Department of Transportation

SH 21A/Bradley Road
City of Colorado Springs

RE: Veterans Victory (aka-Villages at Waterview North) {DEPN-23-0002; SUBD-23-0008}

Figure 20  
CDOT/Powers Boulevard Improvements

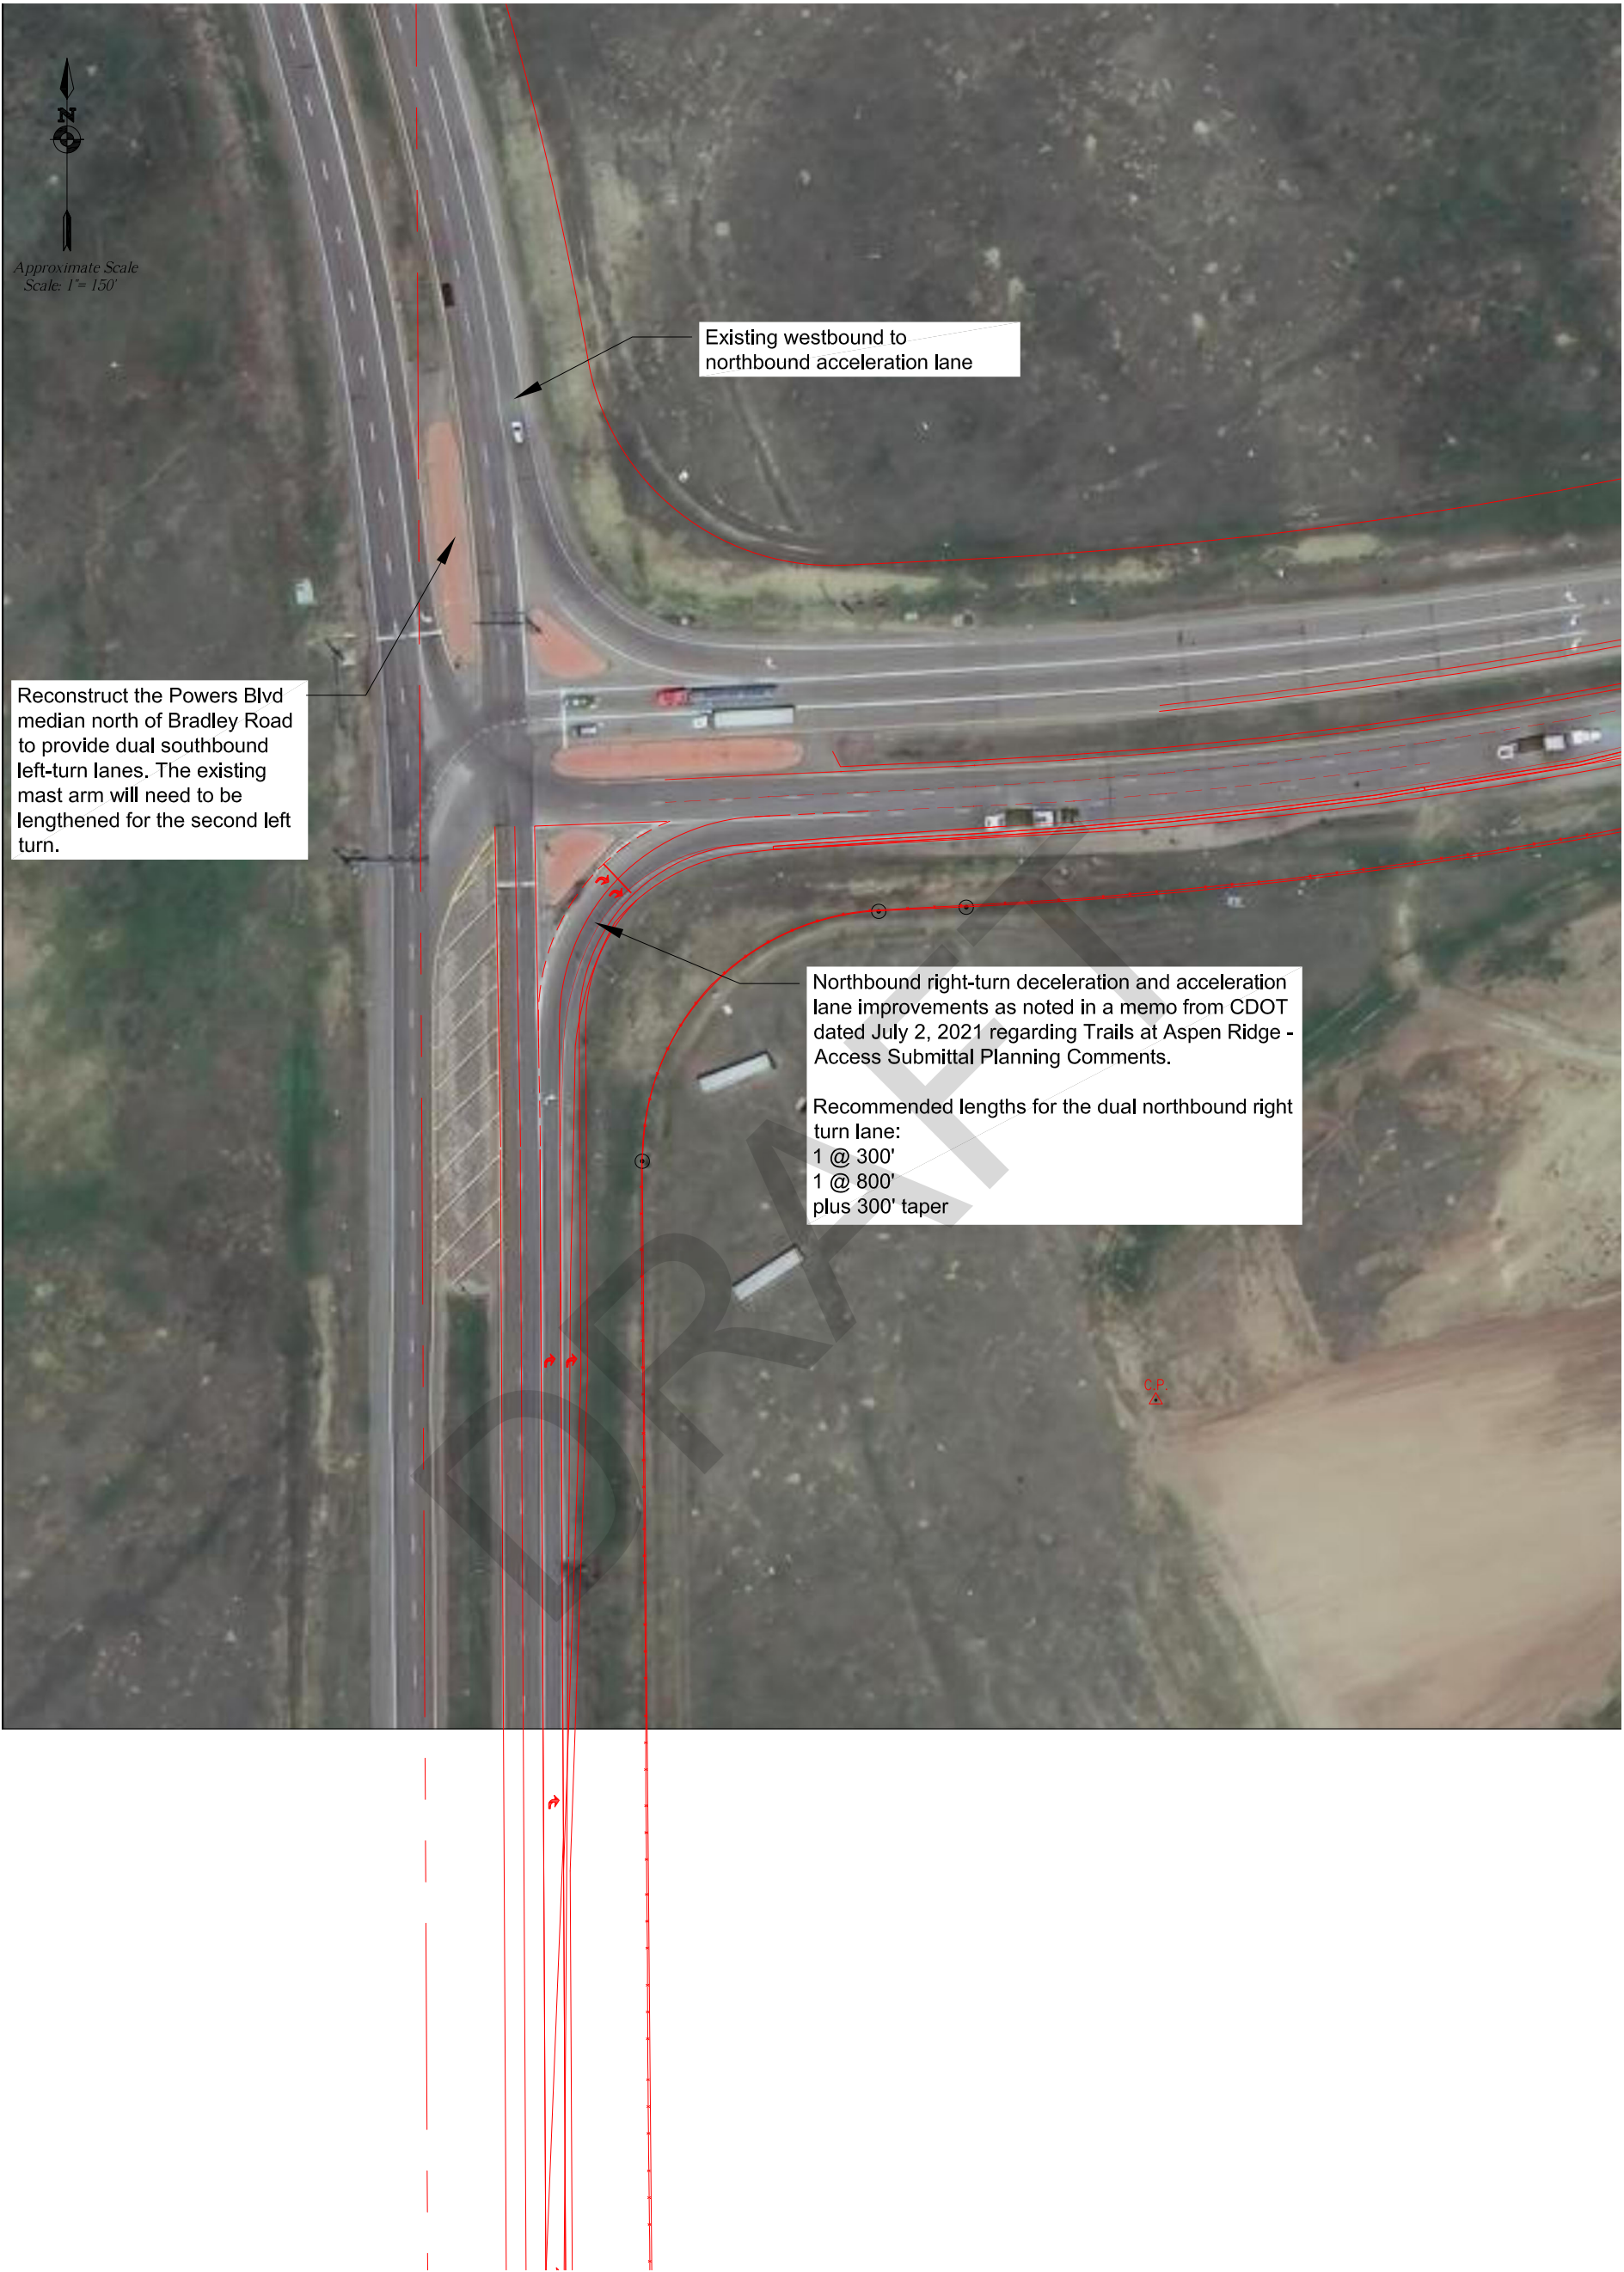
- The following conditions are a requirement for the Notice to Proceed and are agreed upon in TIS (Table 4):
 - a) An additional left turn lane from southbound SH21A/Powers Blvd. to eastbound Bradley Rd. is required to be installed. This requirement creates a southbound dual left traffic movement at the intersection of SH21/Bradley Rd. The construction plans will require adjustment to the existing traffic signal, extending the arm to cover the additional southbound left turn lane. The Development Engineering team will need to confirm that the existing traffic signal pole and caisson can support a longer arm. Otherwise, the entire signal pole will need replaced with the access permit.

- b) An additional right turn lane from northbound SH21/Powers Blvd. to eastbound Bradley Rd. shall be required. This requirement creates a northbound dual right turn traffic movement. Northbound right turning traffic lanes from SH21/Powers Blvd onto eastbound Bradley Rd. shall be signalized controlled. This additional lane requires the roadway widening of this turning movement per the State Highway Access Code.

- c) The northbound right turn lane along SH21 to eastbound Bradley Rd. shall be extended further south to allow for additional queuing for the dual right turn movement onto eastbound Bradley Rd. from SH21a/Powers Blvd.
- d) The westbound to northbound free right turn acceleration lane from Bradley Rd. onto SH21/Powers Blvd. shall be extended to the north to allow for additional merging traffic; refer to CDOT access code for proper acceleration lane length and taper.
- e) A collection of escrow funds shall be required for the developments fair share percentage for future intersection/interchange improvements.

- **Roadway improvements are required by this development and will be detailed in the Access Permitting process with CDOT.**
- **CDOT Access concurs Figure 4 roadway improvements required by this development.**
